MEMORANDUM

TO: Jean Fraser, Planner
FROM: Lauren Swett, PE
DATE: July 21, 2016
RE: 415 Cumberland Avenue, Level III Site Plan Application

Woodard & Curran has reviewed the Level III Site Plan Application for the proposed redevelopment located at 415 Cumberland Avenue. The project includes the conversion of the space from commercial office into mixed use commercial and residential market rate apartments. The work includes renovation of the building and some minor site improvements including utilities.

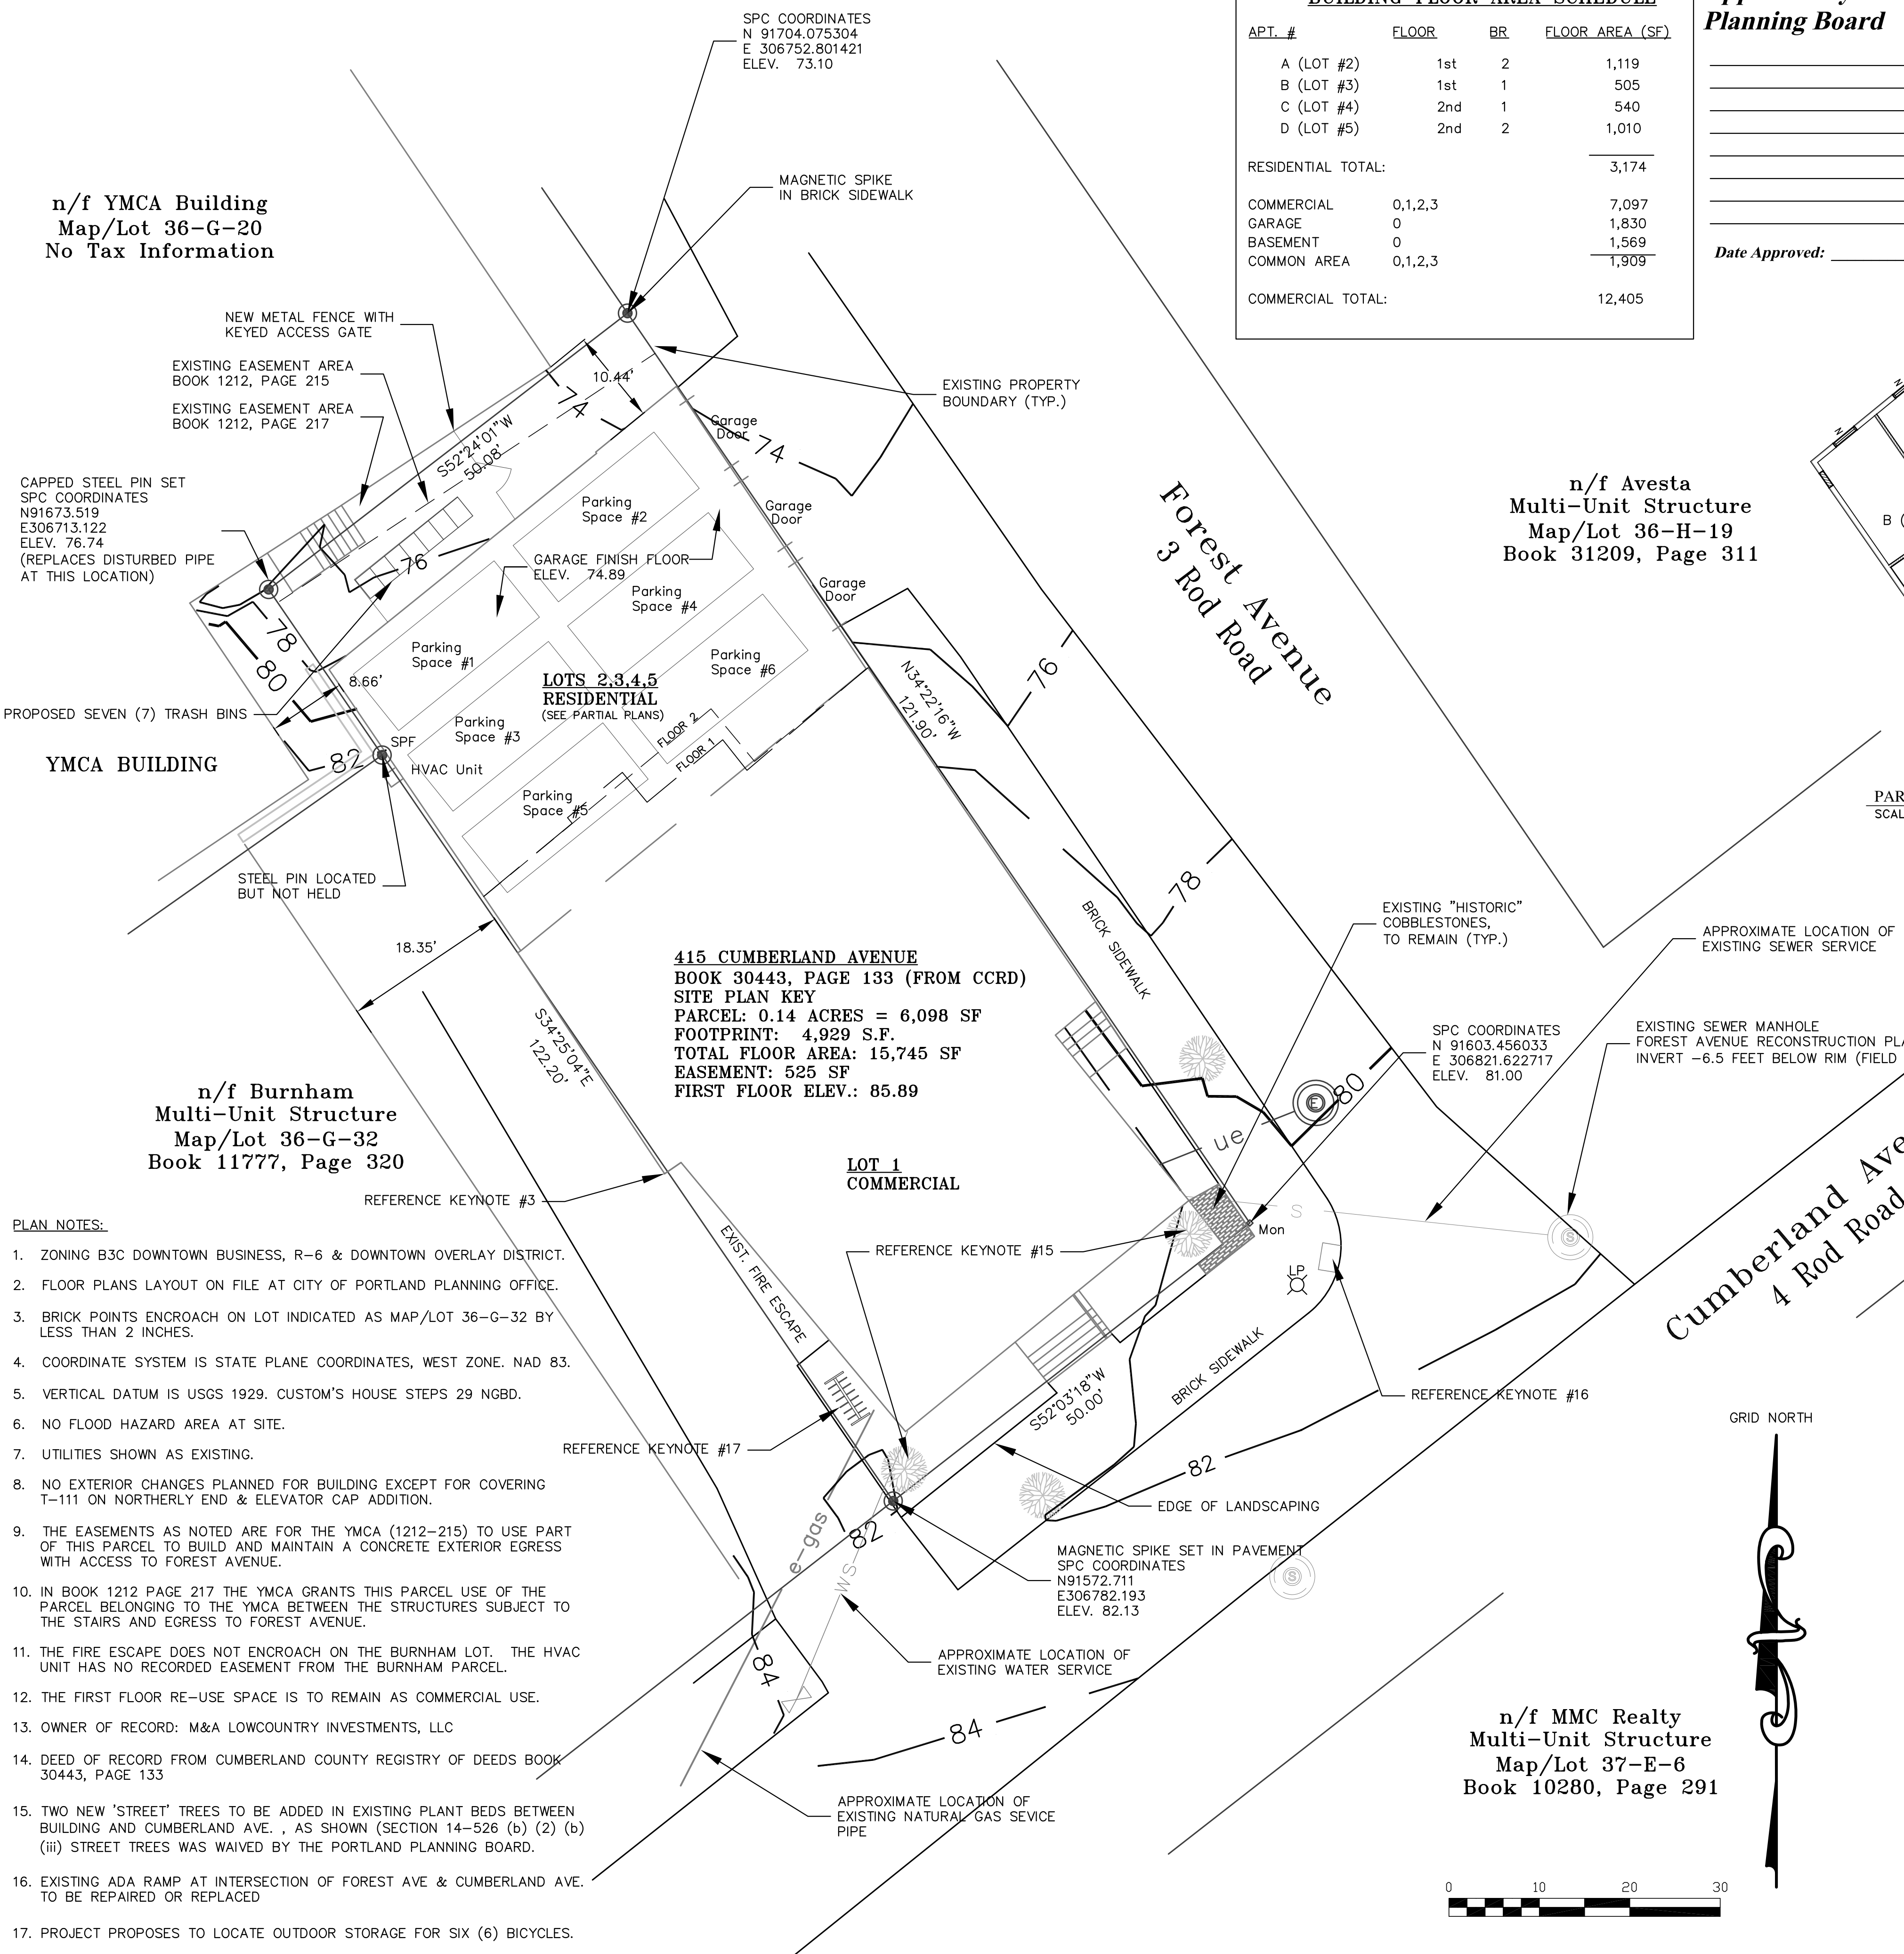
- 3) The Subdivision Plat notes that the existing ADA ramp at the intersection of Cumberland Avenue and Forest Avenue will be repaired or replaced. The site plan should also note that this work will be completed. The ramp and crosswalk layout should be in conformance with the City of Portland Technical Standards, and should be reviewed by the Transportation Division of the Department of Planning & Urban Development prior to construction.
